Consultation Response from KC, Trees		
Land off, Forge Lane, Thornhill Lees, Dewsbury, WF12		
Outline application, including the consideration of access and layout, for two commercial units (use class B2 and/or B8) and associated works		
Date Responded: 03/02/2026	Responding Officer: Hazel Irving	Responding Ref:

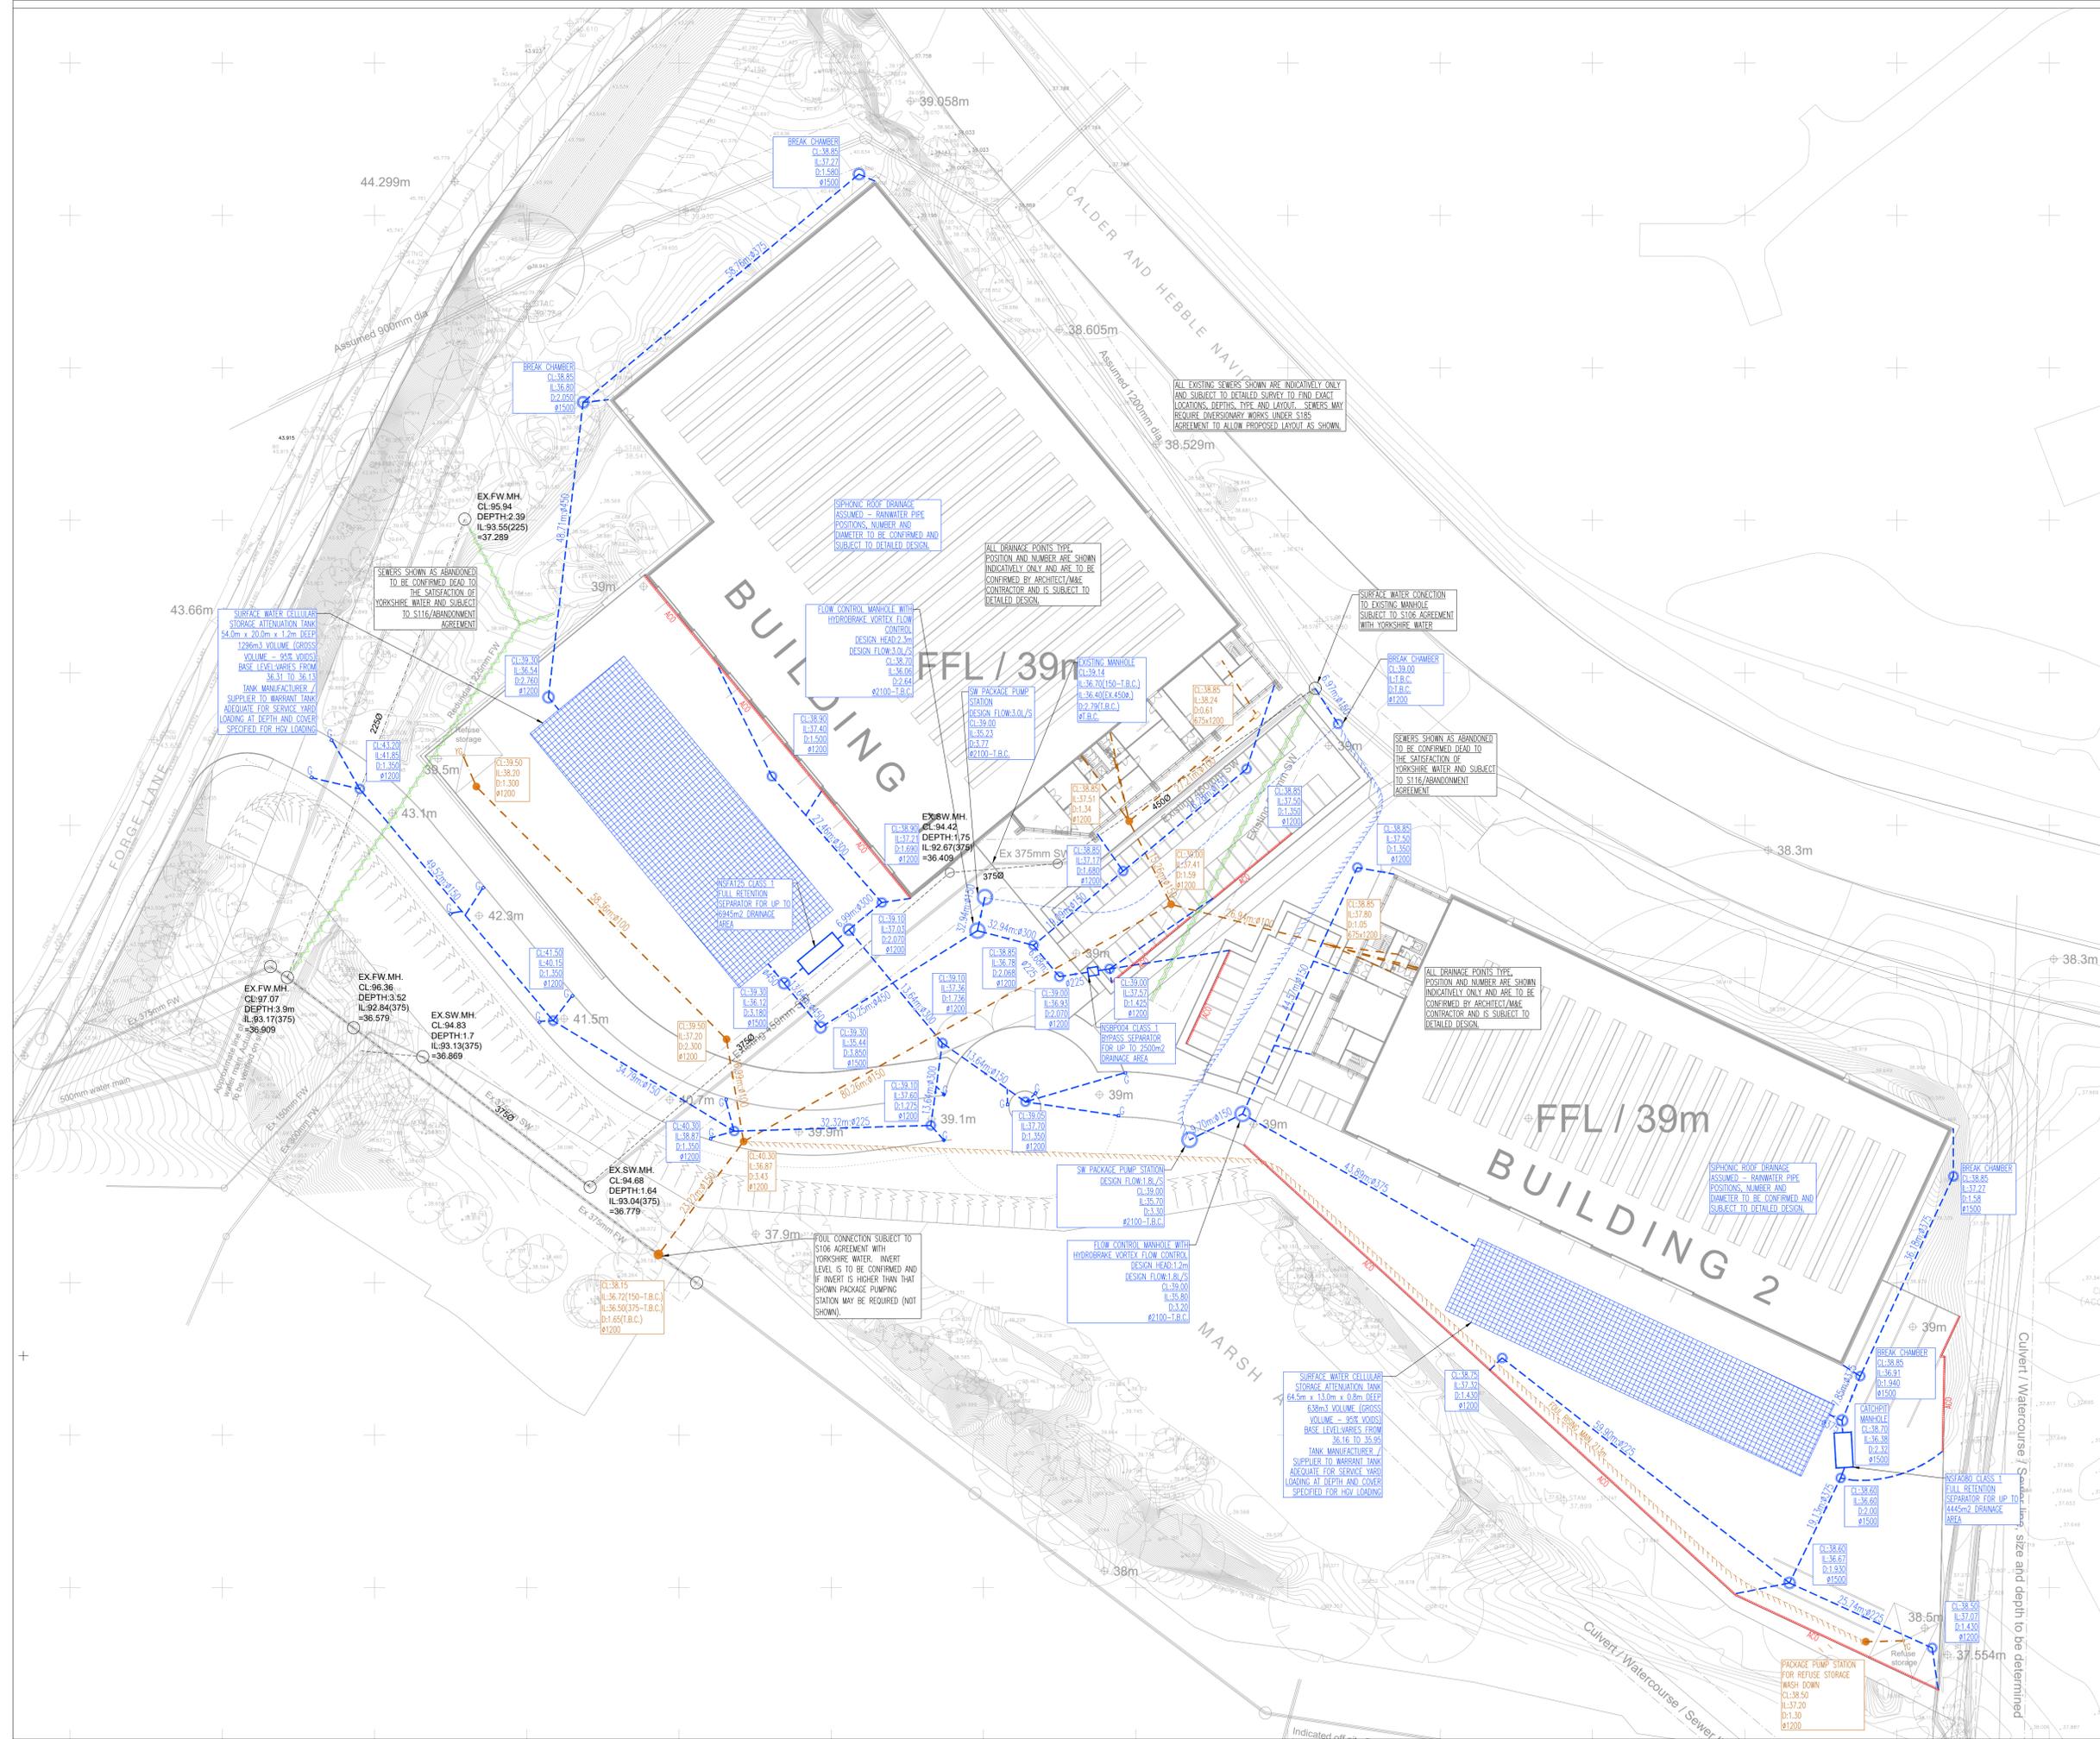
The drainage strategy shown in drawing ref. Drainage Feasibility 2465/01/SK01 within the ARP report Rev A, dated 16/12/2025, suggests that the layout will not pass through the root protection areas of the retained vegetation.

However, an amended AIA should be produced based on the final layout and include utilities and drainage layouts. This should be submitted with an AMS and Tree Protection Plan.
